Our Ref: 21/1245/FUL

### INVALID APPLICATION

**PROPOSAL:** ERECTION OF 2 DWELLINGHOUSES, FORMATION OF  
SHARED ACCESS AND CAR PARKING AREA  
**LOCATION:** Land To South-west Of 8 Glen Road , Leswalt

Drawing NO: 1 **Location Plan and Site Plans.**

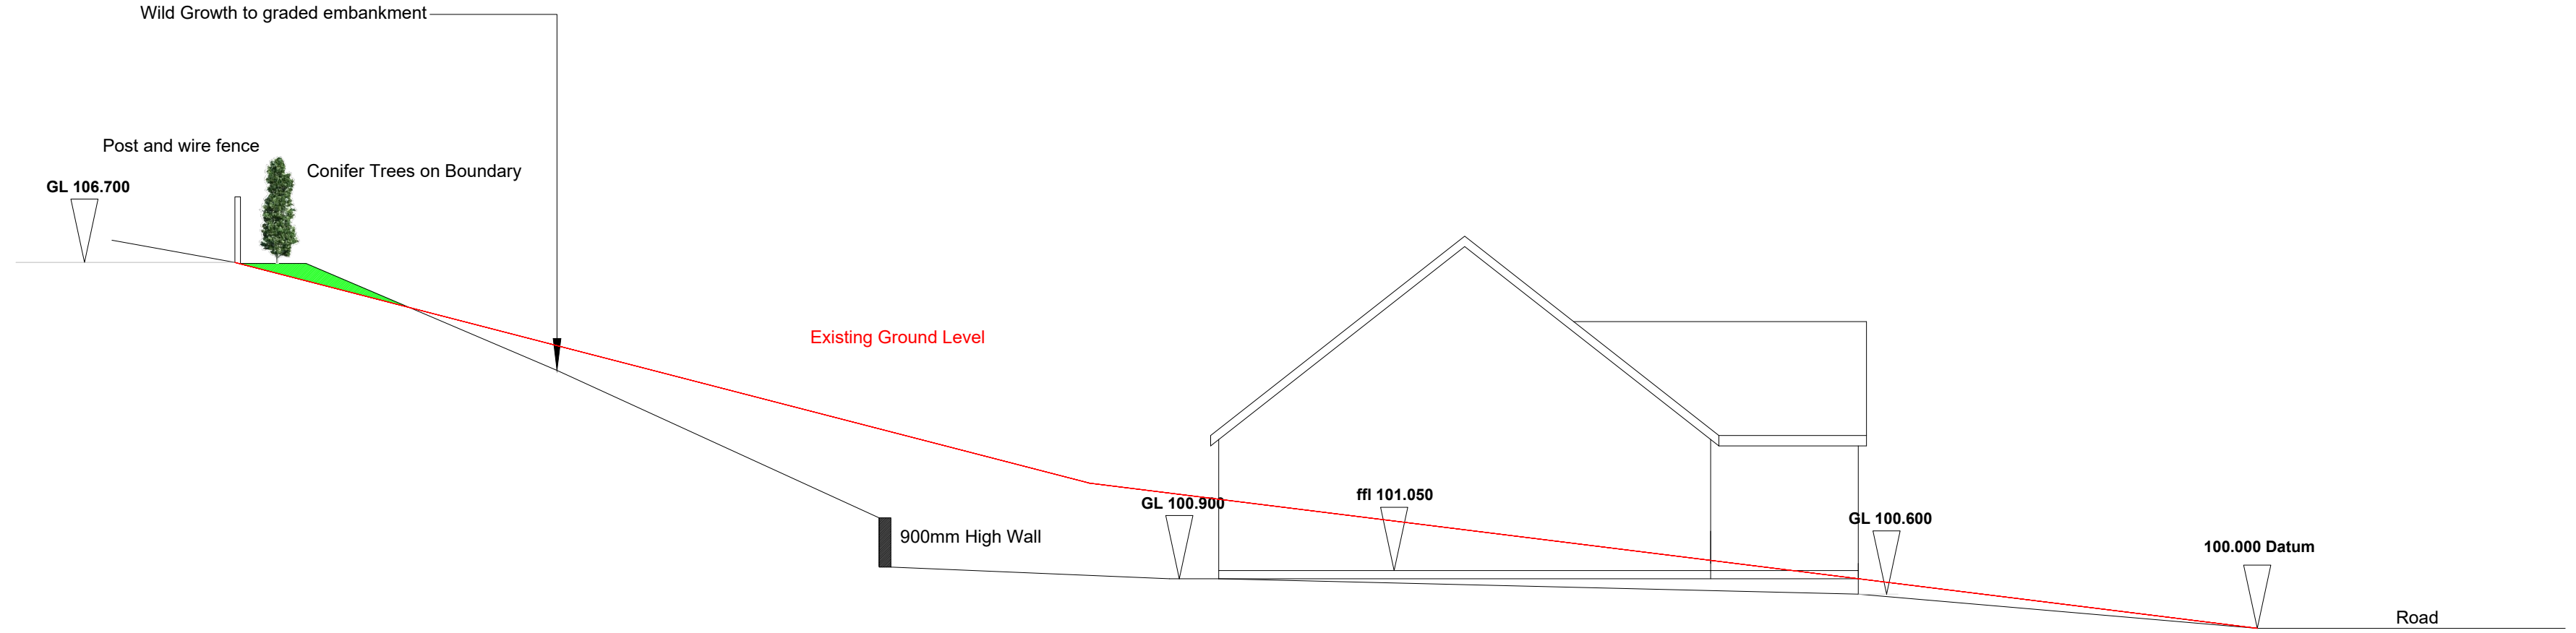
**01. The submitted block plan is of insufficient detail necessary to properly assess this application. Please forward a copy of an amended plan as soon as possible which should also contain the following:**

- All land and buildings located within a 20 metre radius of the application site boundary identified;
- A written dimension showing the distance from any part of your proposals to any part of the application site boundary. Note that if you are proposing multiple buildings or structures then a written dimension will be required from each
